The Sizewell C Project

Natural England's Comments on the Applicant's *Deadline 8 Submission - 8.17 Draft Deed of Obligation - Clean Version Part 2 of 2* [REP8-087], *Deadline 8 Submission - 9.11 Informal Recreation and Green Space Proposals - Revision 1.0* [REP8-135] and *Deadline 9 Submission - 9.114 Response by SZC Co. to Natural England's Comments at Deadline 8 - Revision 1.0* [REP9-023]

Natural England's Comments on the Applicant's *Deadline 7 Submission - 9.12 Preliminary Design and Maintenance Requirements for the Sizewell C Coastal Defence Feature - Revision 3.0* [REP7-101] and *Deadline 9 Submission - 9.31 Storm Erosion Modelling of the Sizewell C Soft Coastal Defence Feature using XBeach-2D and XBeach-G - Revision 3.0* [REP9-020]

**Natural England's Comments on Revision 3.0 Southern North Sea Site Integrity
Plan [REP8-048]**

Figure 12: Recharge Interval (RI) in years with the Dutch Design Method (DDM) applied calculated from the mean erosion rate, maximum erosion rate and the mean erosion rate with 1 STD. Exponential trendlines were fitted to each set of rates.

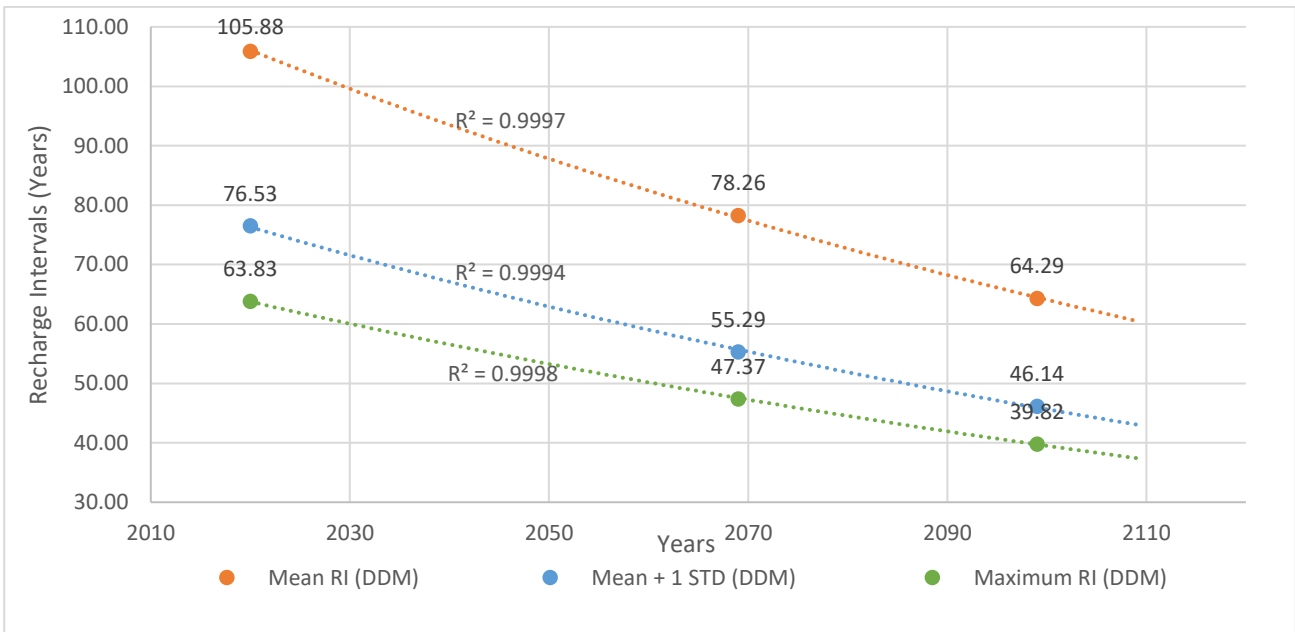
6. Page 54 seems to be analysis of recharge intervals and volumes which reinforces the view that the larger the beach cobble size, the fewer number and interval of recharges would be required. This is obviously relevant to the question as to what the most appropriate sediment size and grain is to maintain condition of drift line habitat features.

Figure 15. Pre and post storm beach profiles for a range of particle sizes using the 1D sand and gravel versions of XBeach for 2099 sea levels. The section shown is in the centre of the Sizewell C frontage. XBS = XBeach sand and XBG = XBeach gravel. The legend shows the sediment diameter used.

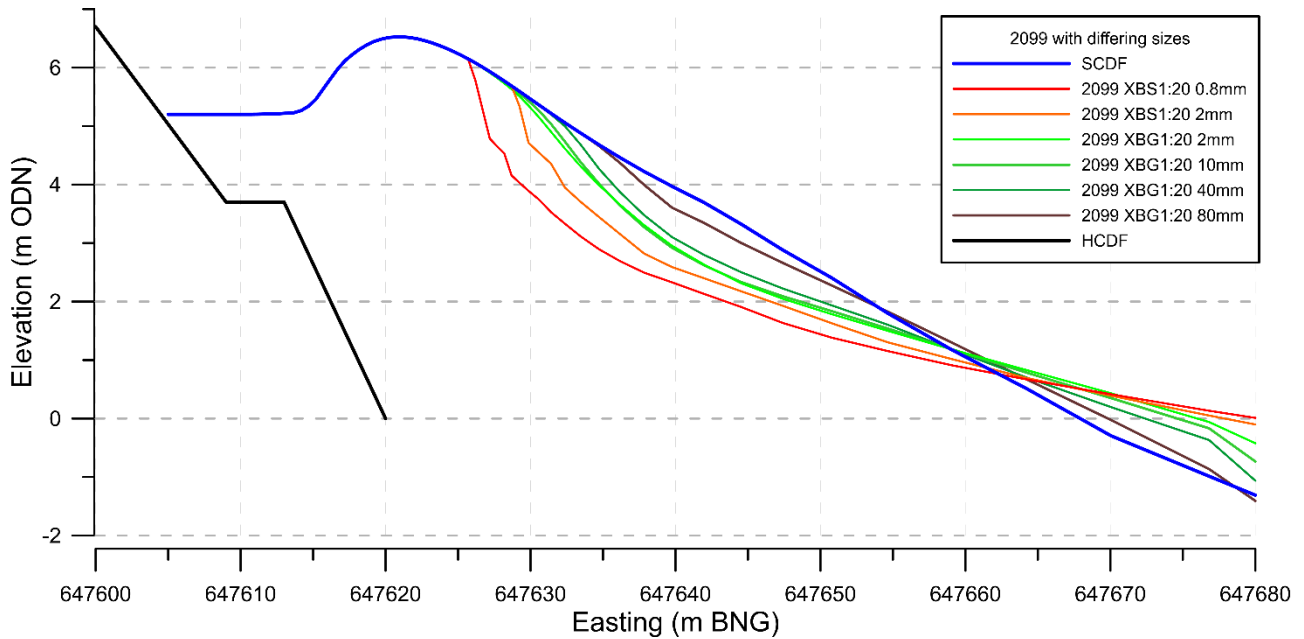
4. On page 37 with regards SCDF composition, two scenarios are presented which we understand are new and different scenarios to those presented in Version 2 of this report. These are both at the larger end of the size scale so reinforces our advice that further modelling of particle size is needed at this stage to be confident on the conclusion with regards AEol/adverse effects on annual drift line communities.

7. Re the conclusion on page 71, this again emphasises the desirability of larger cobble sizes in the beach recharge material, with no exploration of what a different cobble composition from the existing default beach substrate might mean for the condition of foreshore habitats. It is repeated here that further work (as highlighted above in our comment 1) is still anticipated to refine the options. We therefore reiterate our advice that this information should be provided now in order to inform conclusions on AEol/adverse effects at this time.
